from
**Southern
Water**

Our ref
PLAN-039305

Proposal: Medical centre with pharmacy retail unit & other ancillary uses together with access onto Barnham Road, associated car parking and other hard and soft landscaping works. This site is in CIL zone 2 (Zero Rated) as other development.

Site: BN/62/21/PL - The Croft Surgery, Barnham Road, Eastergate PO20 3RP.

C Drainage Layout Plan

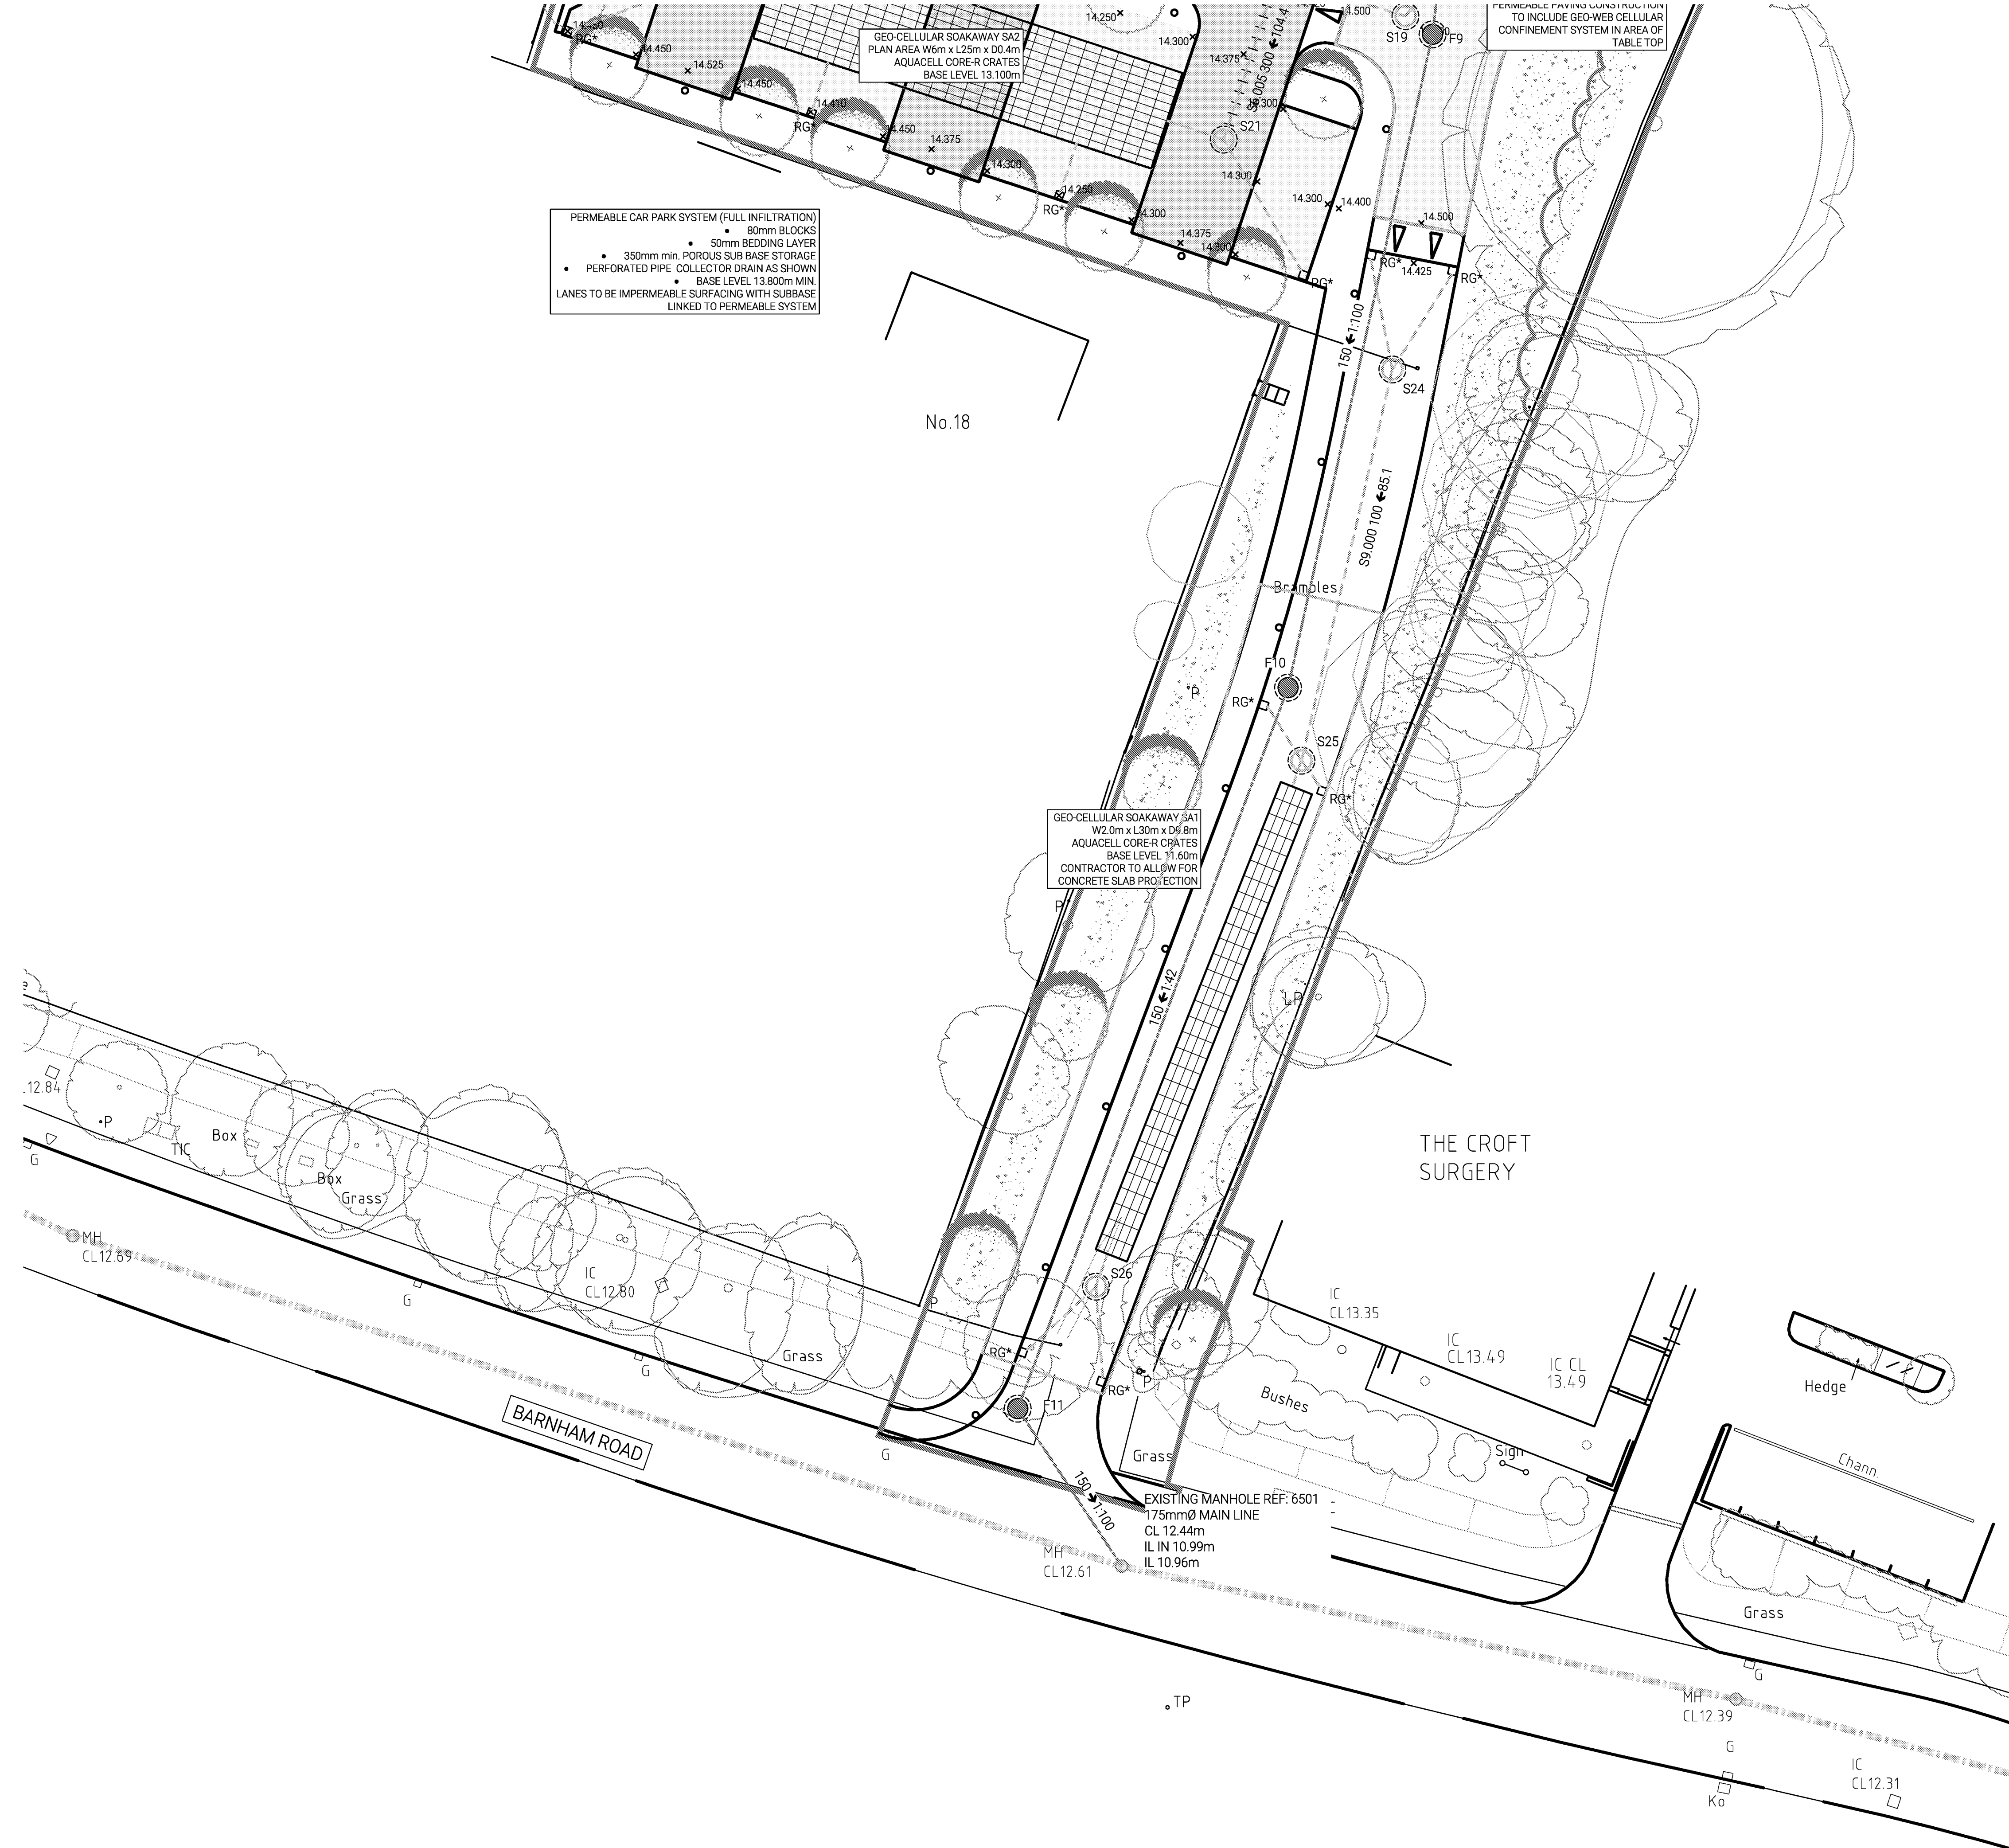
- The 150 mm public foul sewer requires a clearance of 3 metres on either side of the gravity sewers to protect it from construction works and to allow for future access for maintenance.
- No development or tree planting should be carried out within 3 metres of the external edge of the public gravity sewer without consent from Southern Water.
- No soakaway, swales, ponds, watercourses or any other surface water retaining or conveying features should be located within 5 metres of a public sewer.
- All existing infrastructure should be protected during the course of construction works.

Furthermore, it is possible that a sewer now deemed to be public could be crossing the development site. Therefore, should any sewer be found during construction works, an investigation of the sewer will be required to ascertain its ownership before any further works commence on site.

We request that should this application receive planning approval, the following condition is attached to the consent: "Construction of the development shall not commence until details of the proposed means of foul and surface water sewerage disposal have been submitted to, and approved in writing by, the Local Planning Authority in consultation with Southern Water.
